Harnett County
Application Tracking Individual Step Maintenance

Application number : 18 50044105
Application type : CP ADD & ALTER RESIDENTIAL
Revision number :
Path/Step/Seq/Agency . . . : A 20 00 ENVIRONMENTAL HEALTH
Date submitted, resulted . . : 61218 _____
Status code (F4) : _____
Reviewed by (F4) : _____
Revised est cpl date : 61818
Copies of plans : _____

SITE PLAN APPROVAL
 DISTRICT PA-40 USE 812D
 BEDROOM

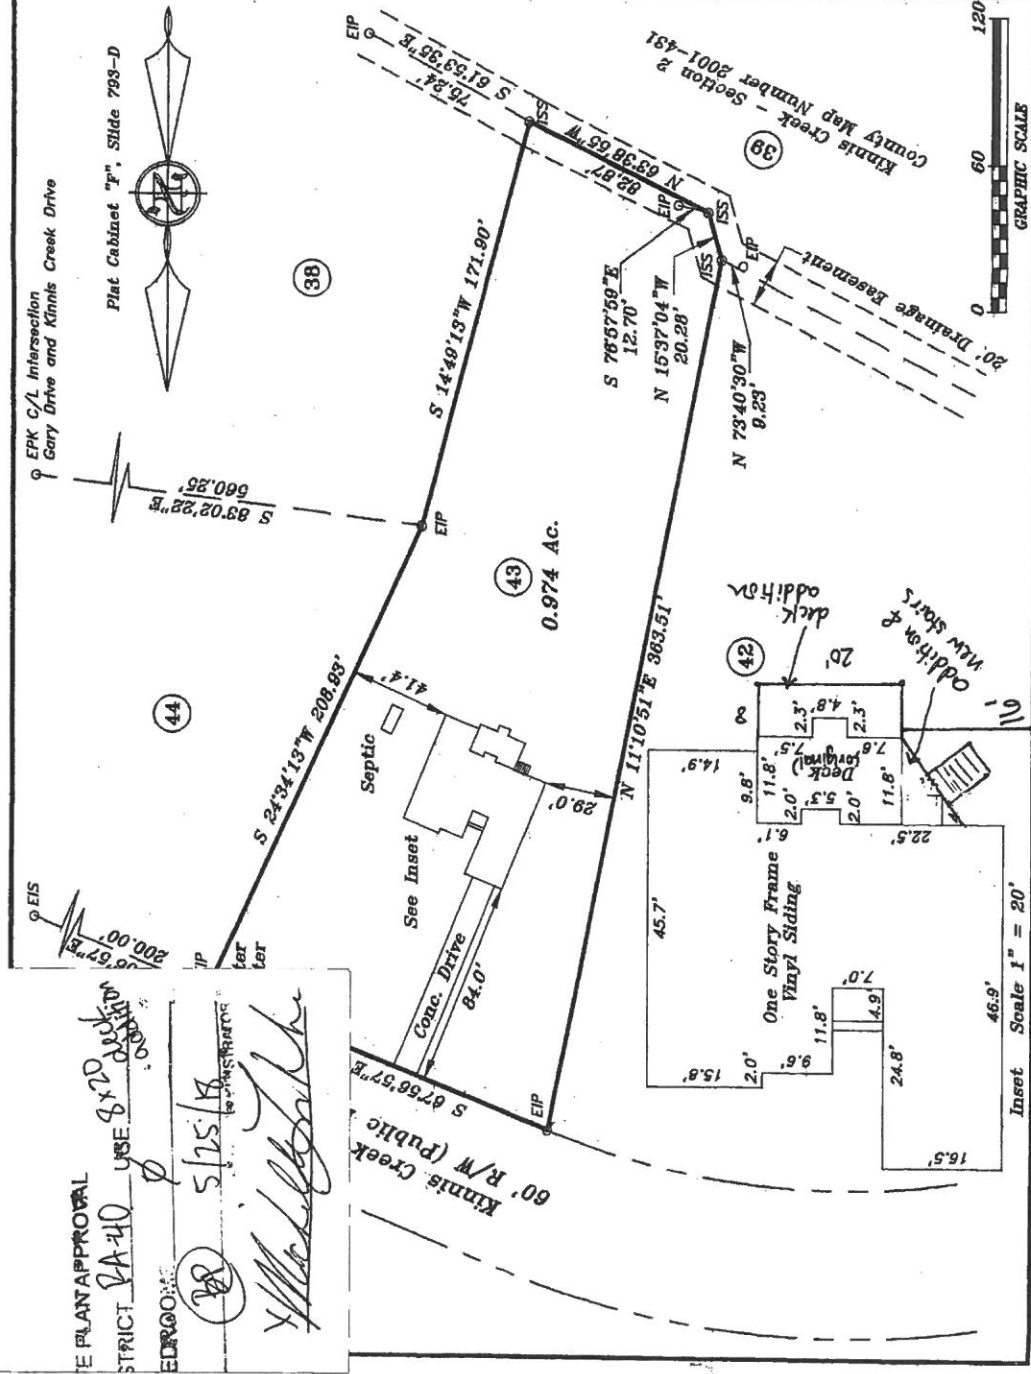
- 1.000 PER OLIVER TOLKSDORF ANY BUILDING TO BE 5' FROM SEPTIC TANK
AND/OR FROM DRAIN LINE. DRAIN LINE RUNS UNDER DECK WITH
DECK POSTS WITHIN 5' OF DRAIN LINE. ANY QUESTIONS CALL
910-893-7547
